On behalf of Navenby Energy Limited (the “Interested Party”), I write in relation to the Fosse Green Energy Development Consent Order (DCO) application submitted by Fosse Green Limited (“FGL”), specifically regarding the proposed cable route associated with the FGL project.

The land on which the Interested Party holds an interest is the subject of a Battery Energy Storage System (BESS) planning application (ref. 25/0533/FUL), which North Kesteven District Council validated on 15 May 2025. That application is a live planning consideration and predates FGL’s DCO application.

Principal Site Internal Cable Route
Corridor

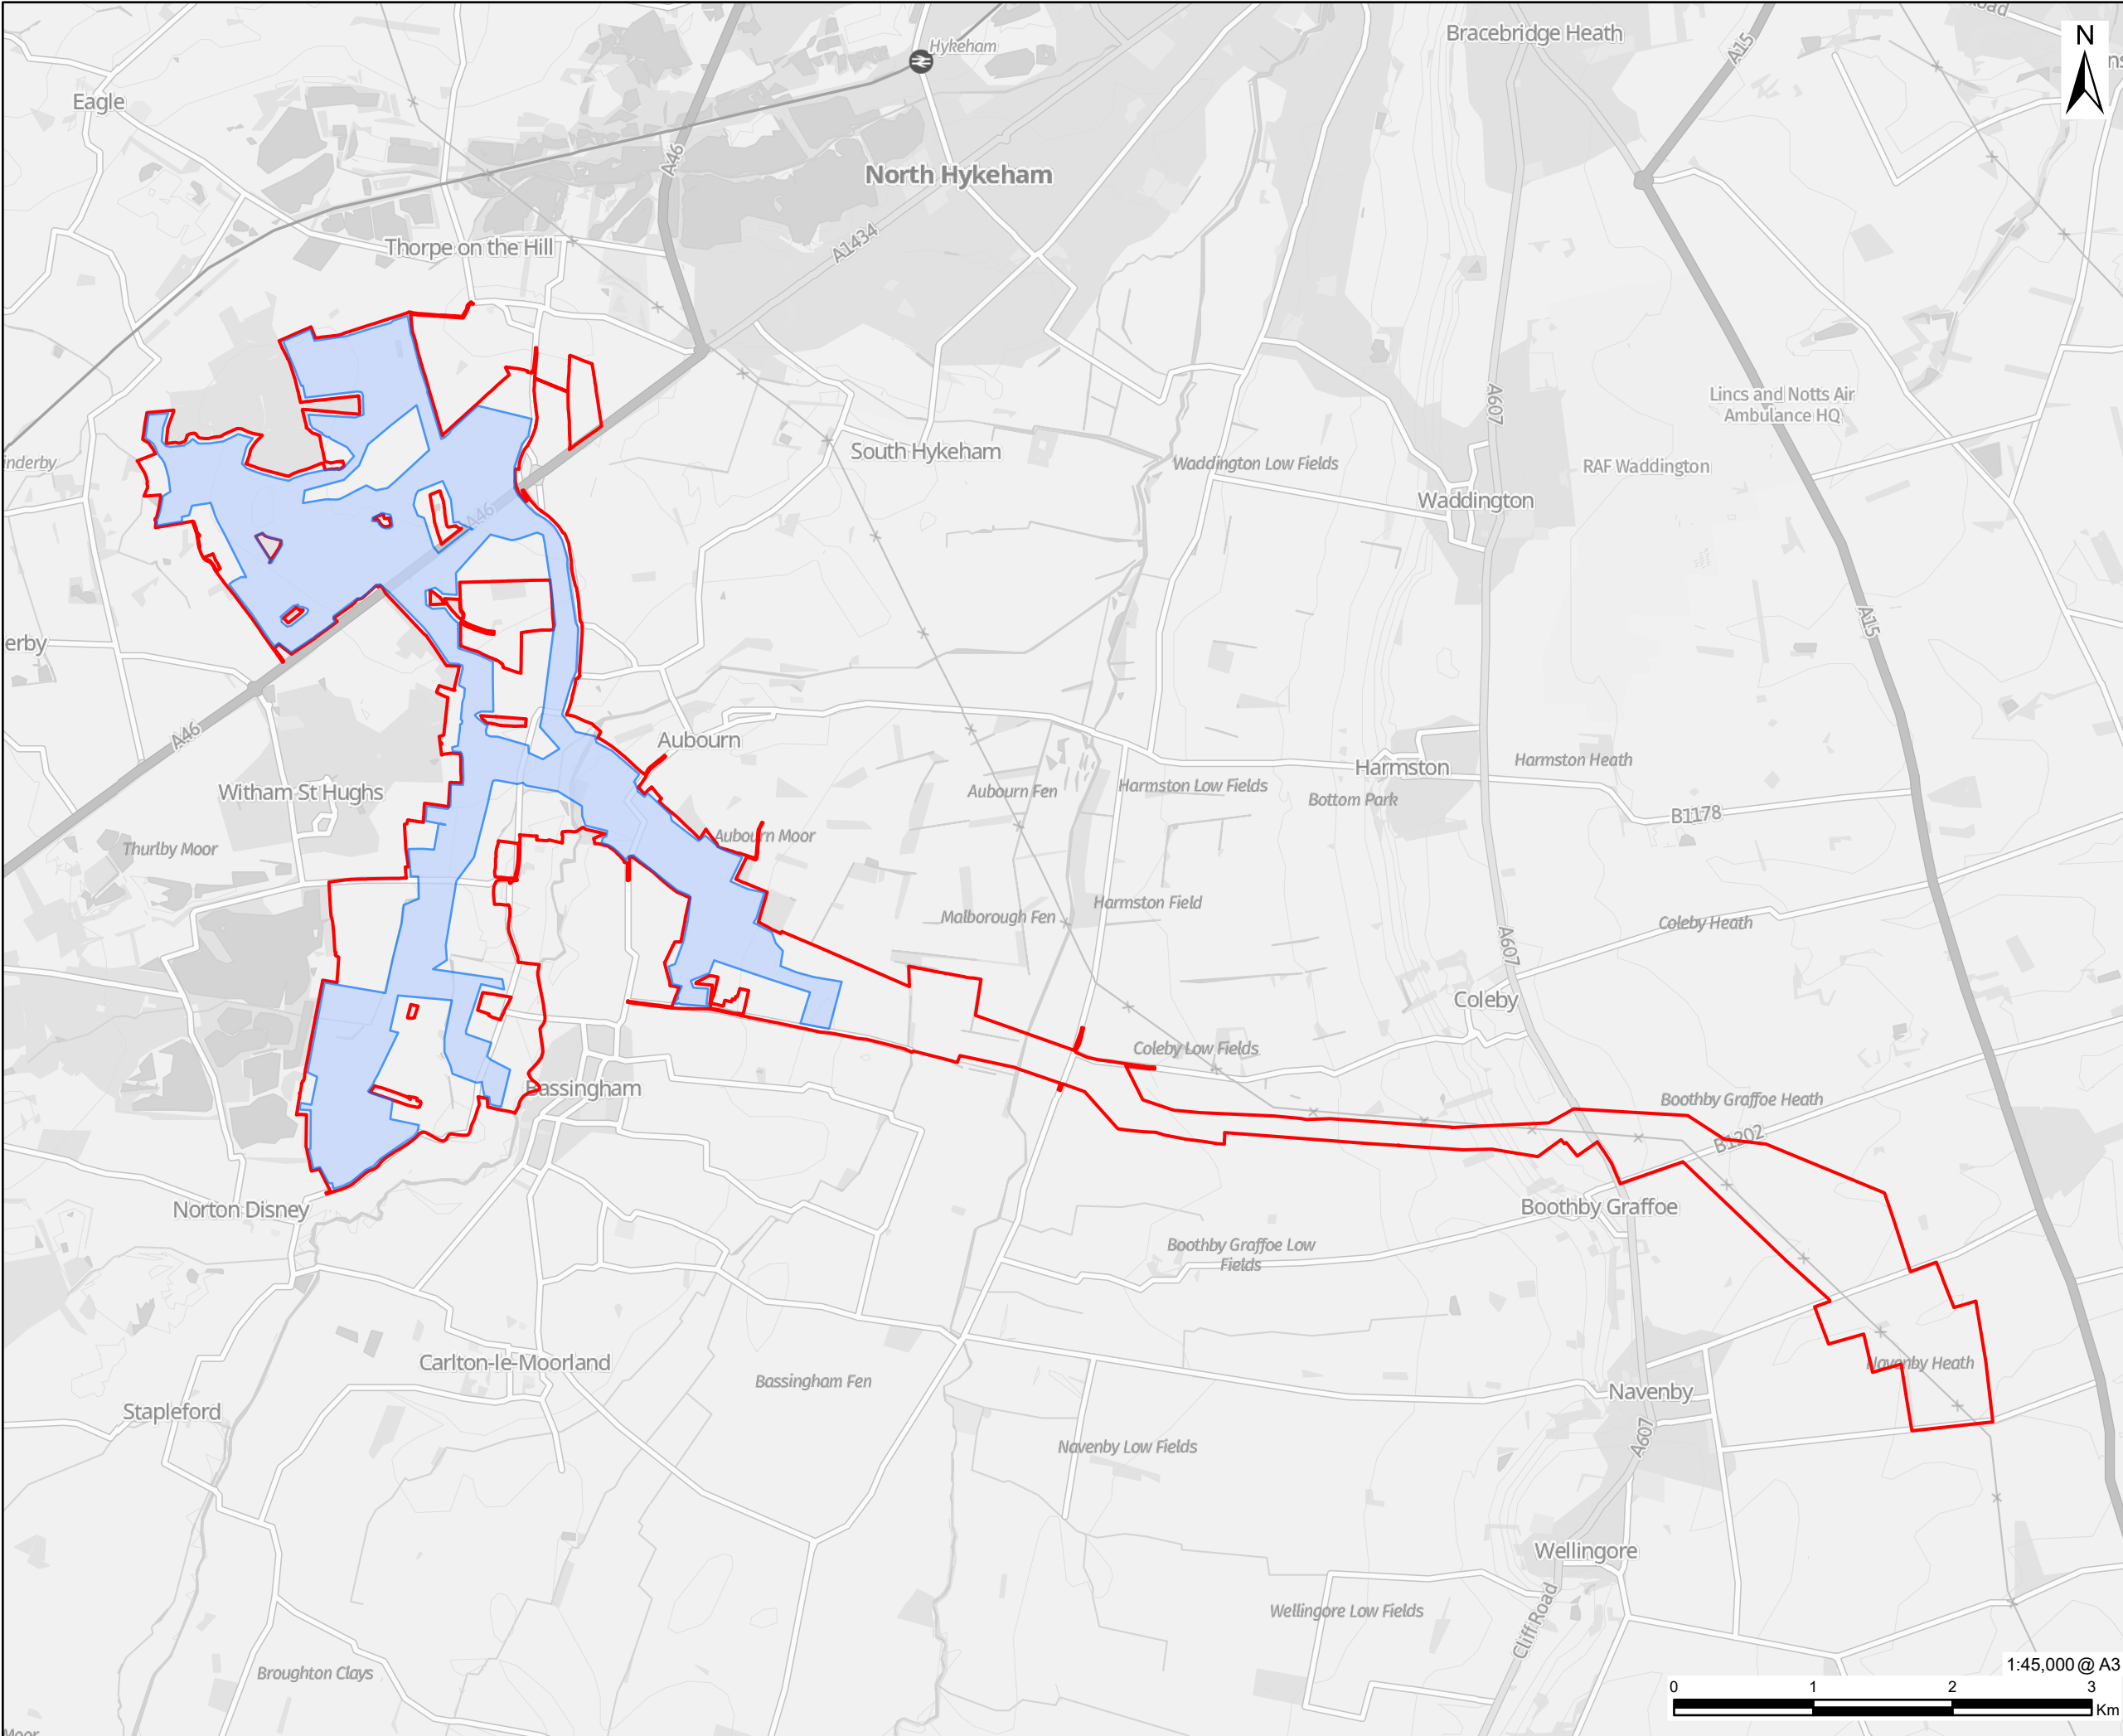
The proposed grid connection cable route submitted by the Applicant (FGL) for their proposed project cuts through the red line boundary of our LDES project. As defined in the application, FGL’s cable corridor occupies land essential for the delivery and operation of our project. This creates a direct conflict between the DCO proposal and a strategic energy infrastructure project.

The presence of a high-voltage cable and associated easements within the BESS red line would result in the effective sterilisation of the land, preventing any

surface structures within a cable exclusion area, preventing the implementation and operation of the LDES project.

In particular, the exclusion zone would prevent the siting of battery units, transformers, access routes, construction areas, and operational infrastructure, while introducing unacceptable safety, construction, and operational constraints. In practical terms, the coexistence of a third-party electricity cable cutting through our BESS facility area would be incompatible.

I am also concerned that the DCO application provides insufficient clarity as to how the Applicant would access the cable for inspection, maintenance, or fault repair where it passes through or adjacent to the LDES site.

In the event of a cable fault, emergency repair works would likely require unrestricted access, excavation, plant movements, and large working areas. It is unclear how such access could be safely or practically achieved without significant disruption to, or temporary shutdown of, the LDES facility.

Given the above, I am concerned that the DCO application does not adequately recognise or address the conflict with the LDES project. I therefore request that the Examining Authority require Fosse Green Limited to give further consideration to alternative routing options for their export cable, in particular a more southerly alignment, which would avoid the LDES site altogether. Such an approach would remove the delivery risk to the LDES project.
